9th October 2019

Single storey rear extension, new timber boarding & fenestration changes & minor internal alterations. This application affects the character & appearance of the Arundel Conservation Area.

30 High Street Arundel

Section CC 1:100 (North West Elevation)

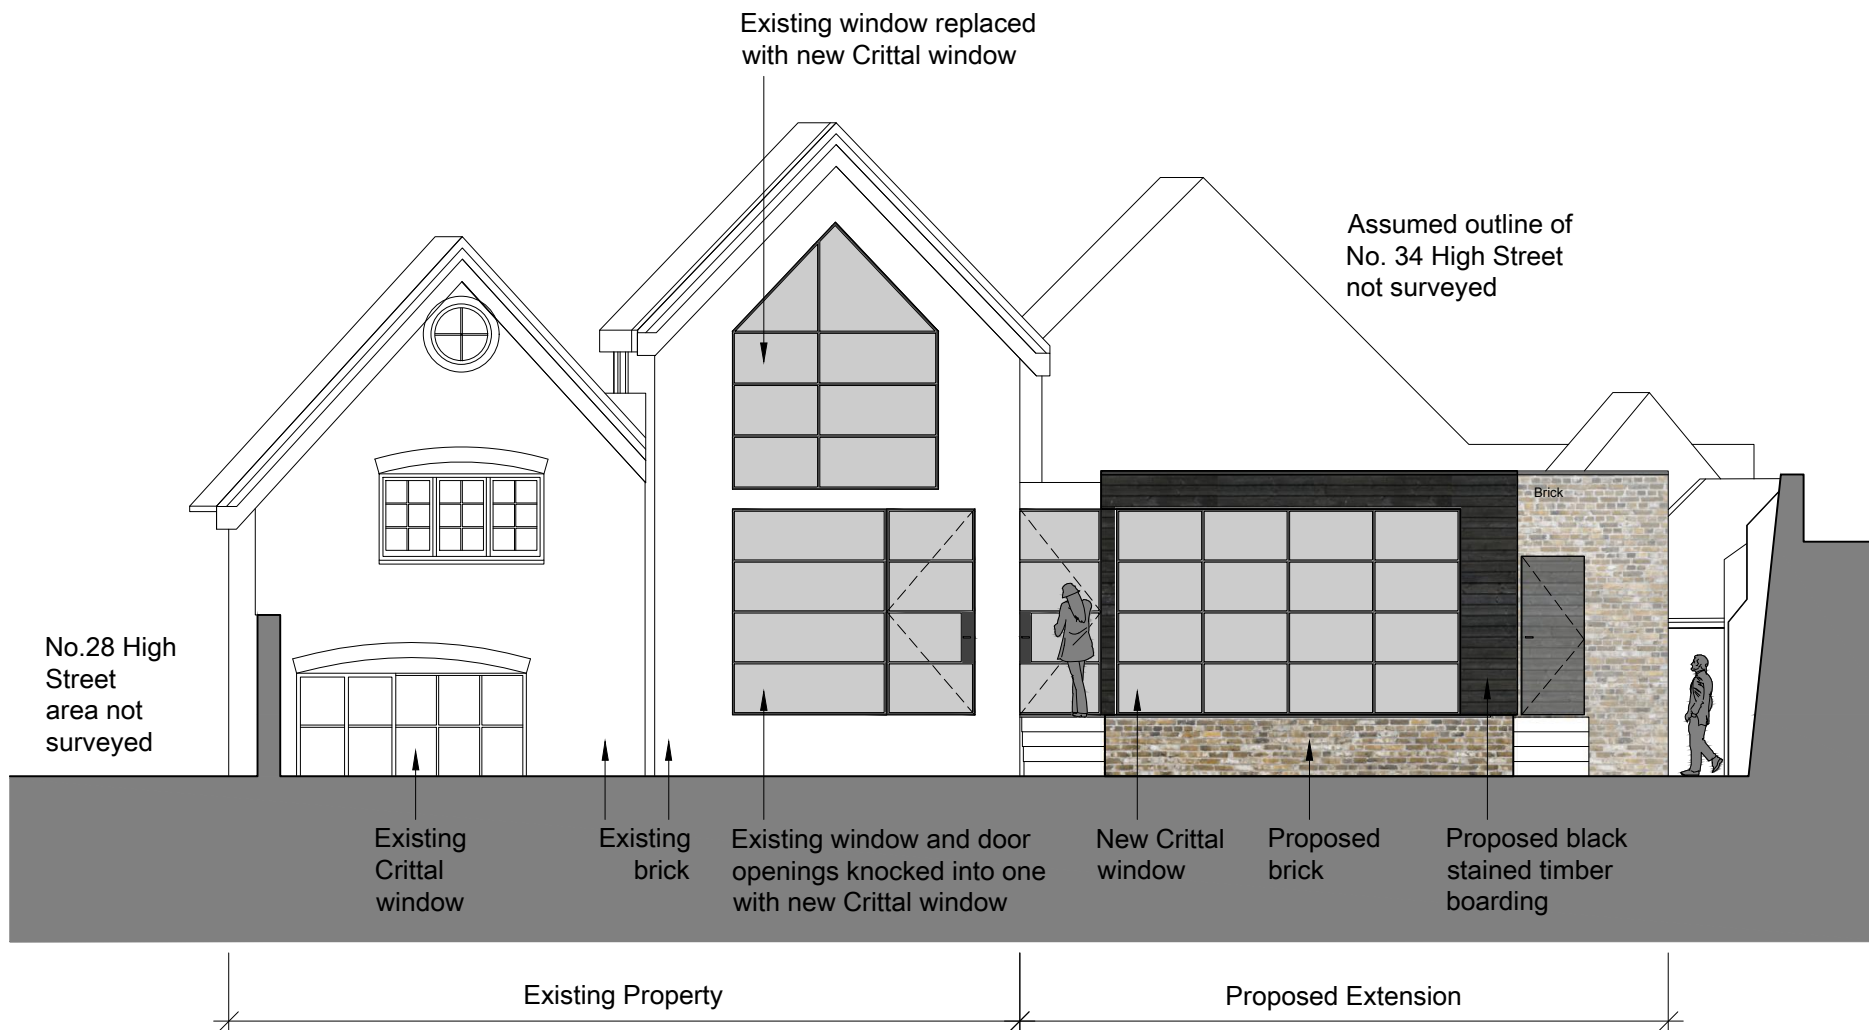
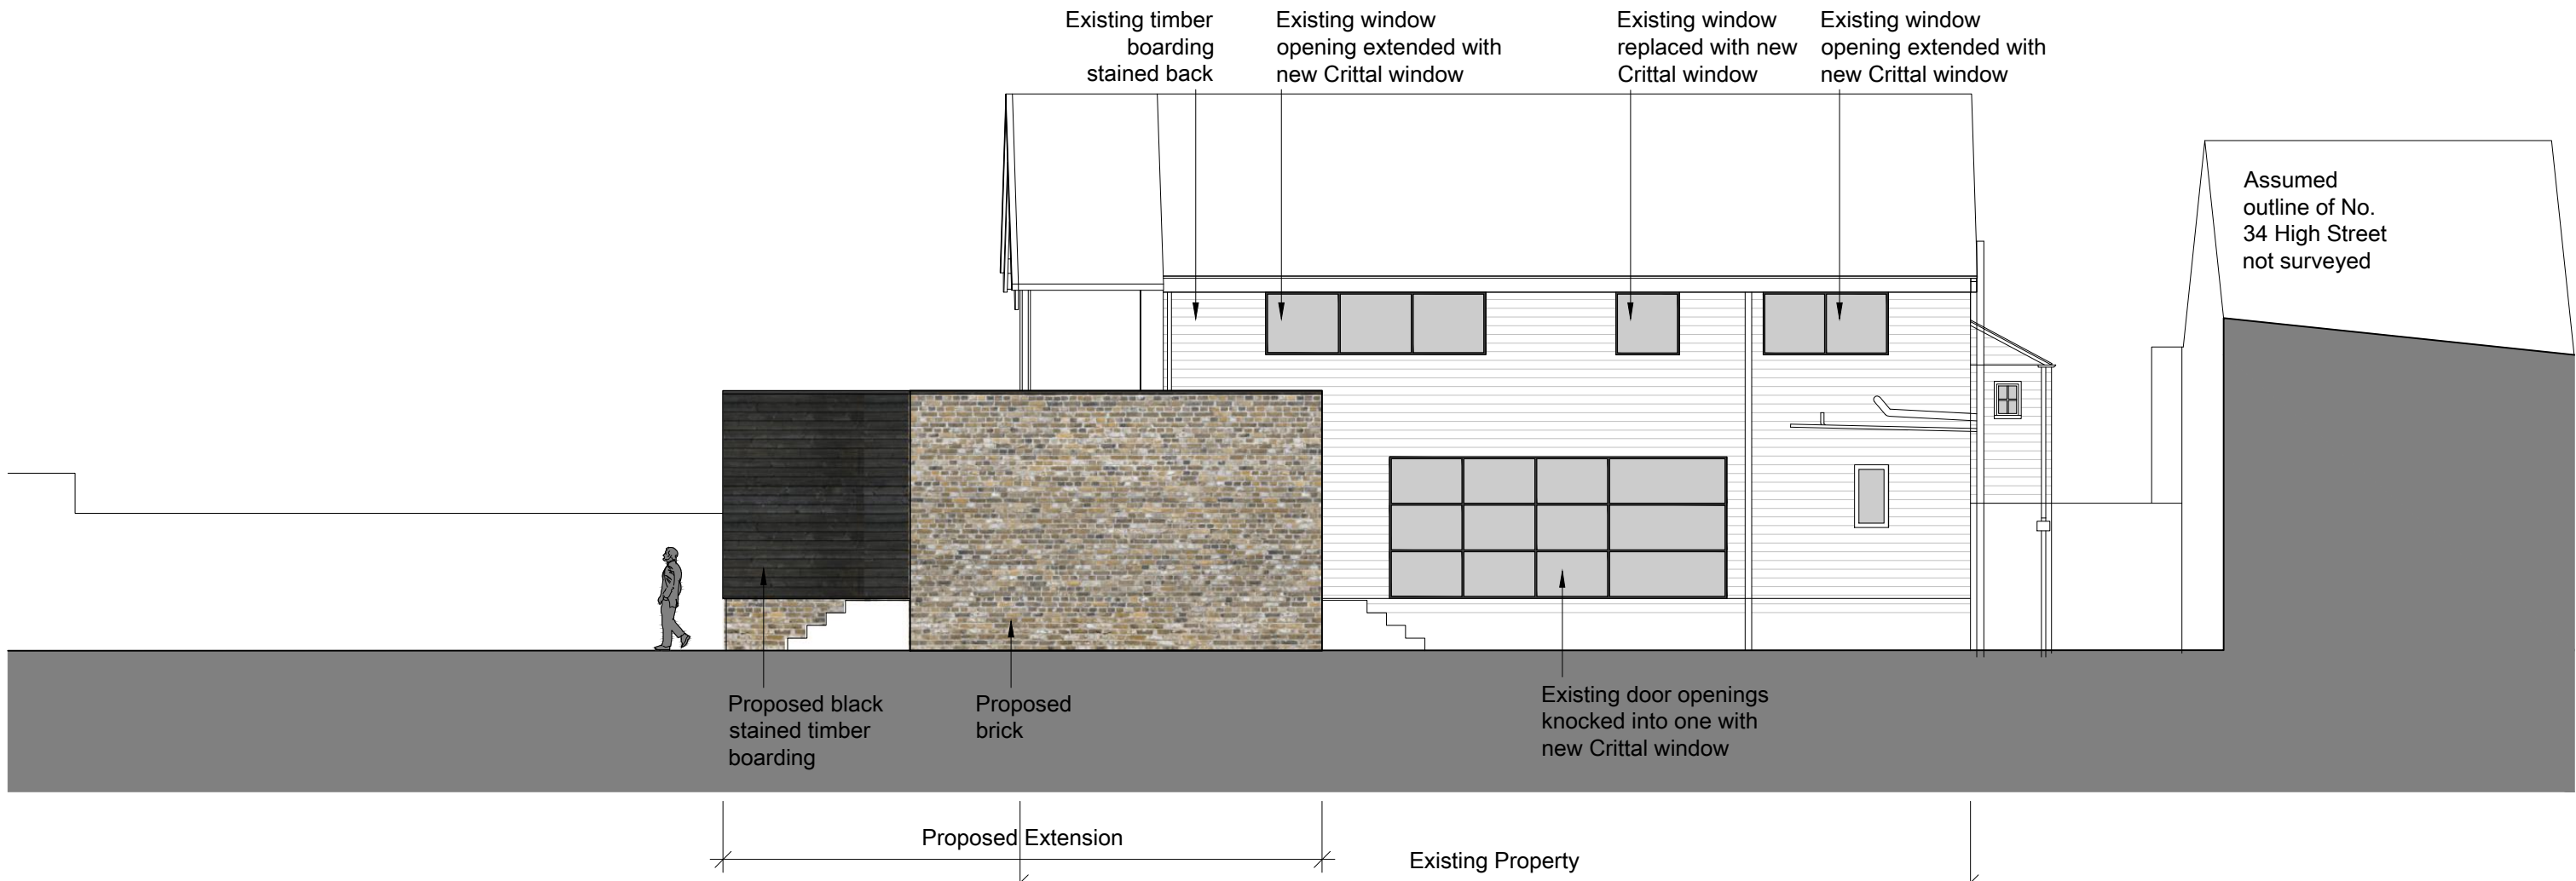
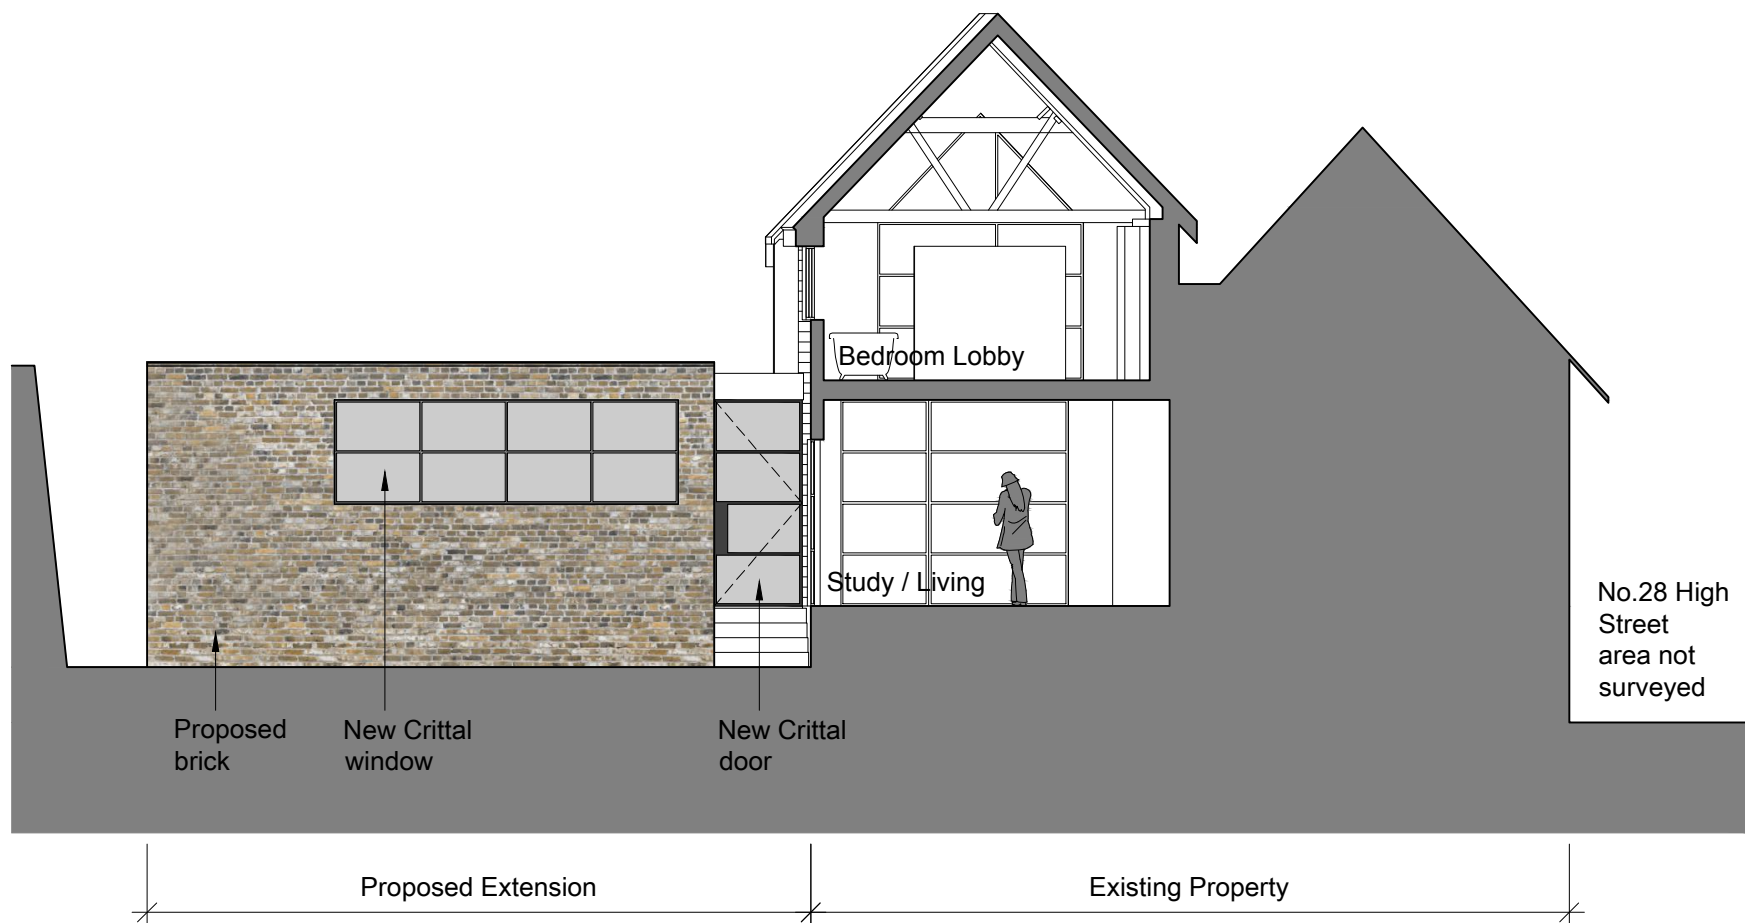
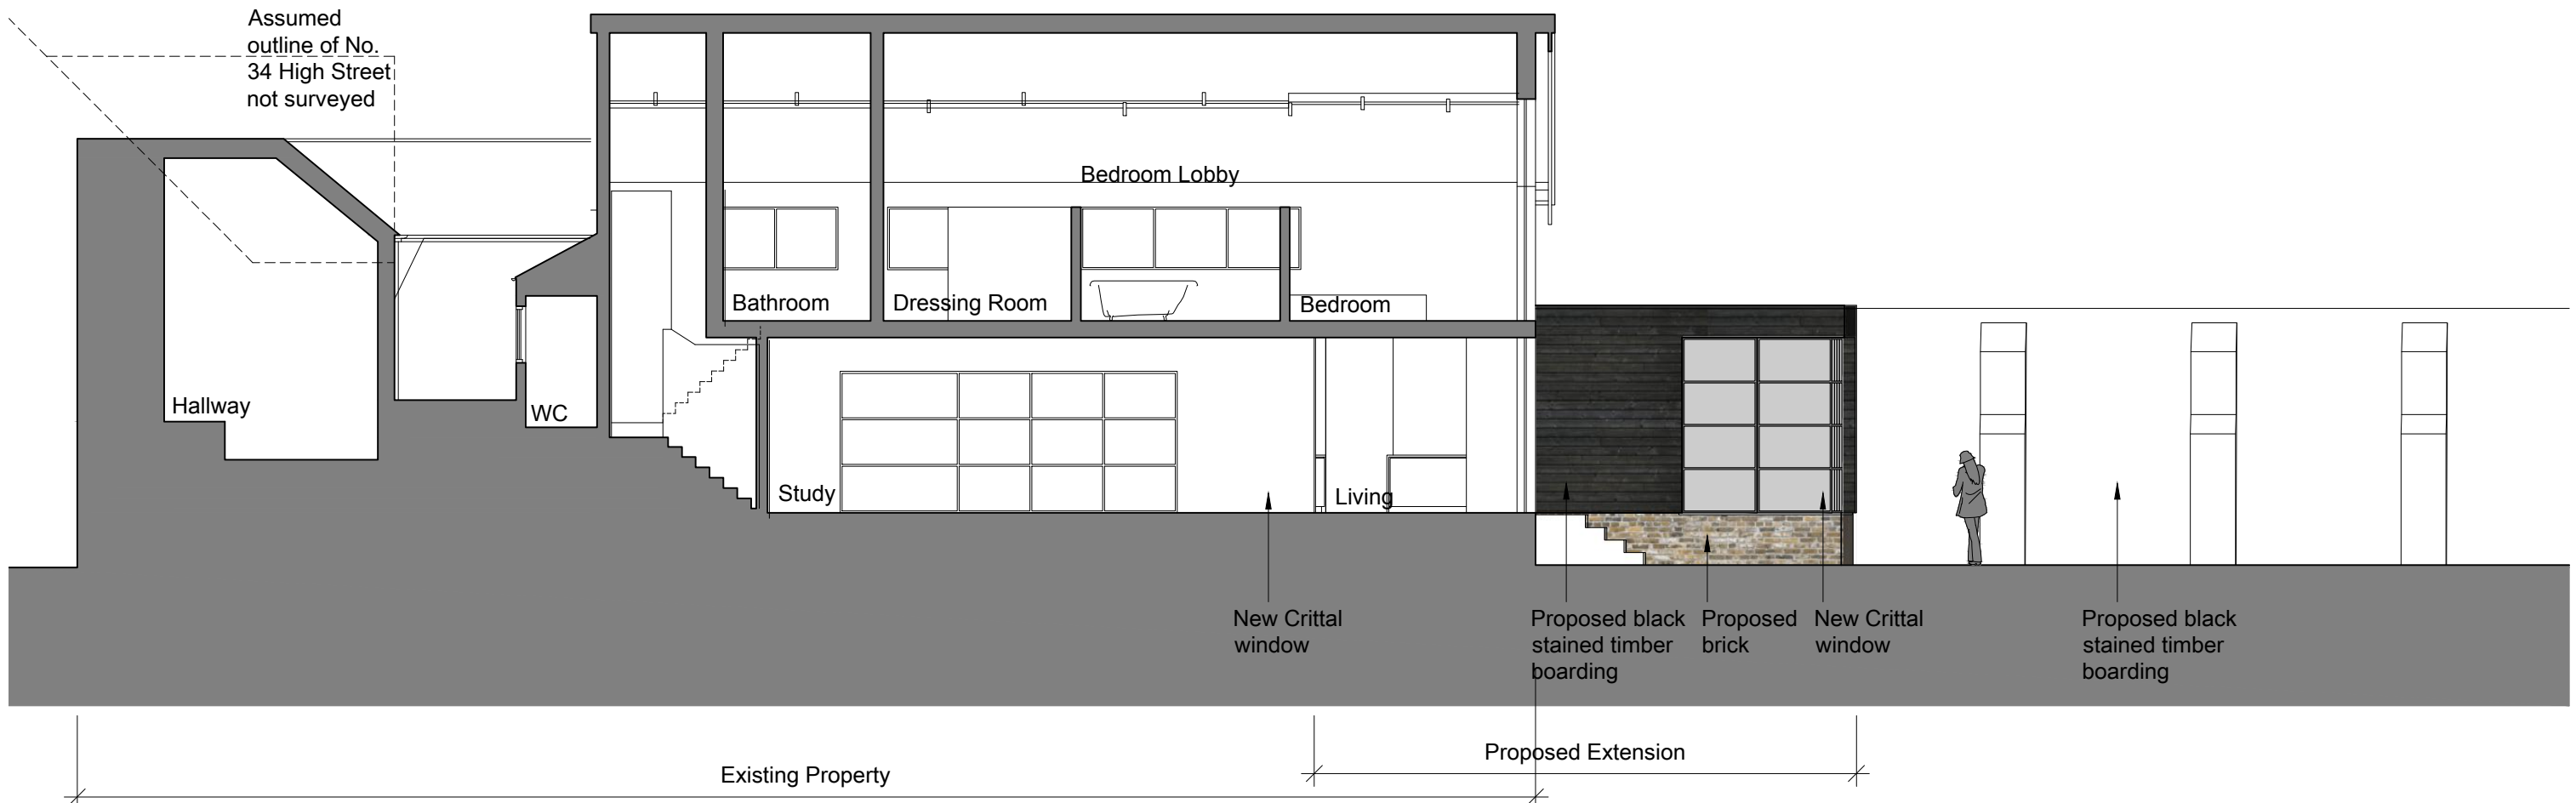
The principal changes to the existing elevations to the rear of the building appear to be located in those parts which were largely reconstructed in the early 20th Century and have little historical or architectural significance. From the submitted plans there appears to be fenestration of inappropriate design at first floor level in the north-west elevation of the existing rear extension.

The alterations to the fenestration of the existing extension involve enlarging existing openings. However, given the extension's low level of historical and architectural significance and the complementary nature of the new fenestration with the design of the proposed extension, there will be no harm to the character or appearance of the conservation area.
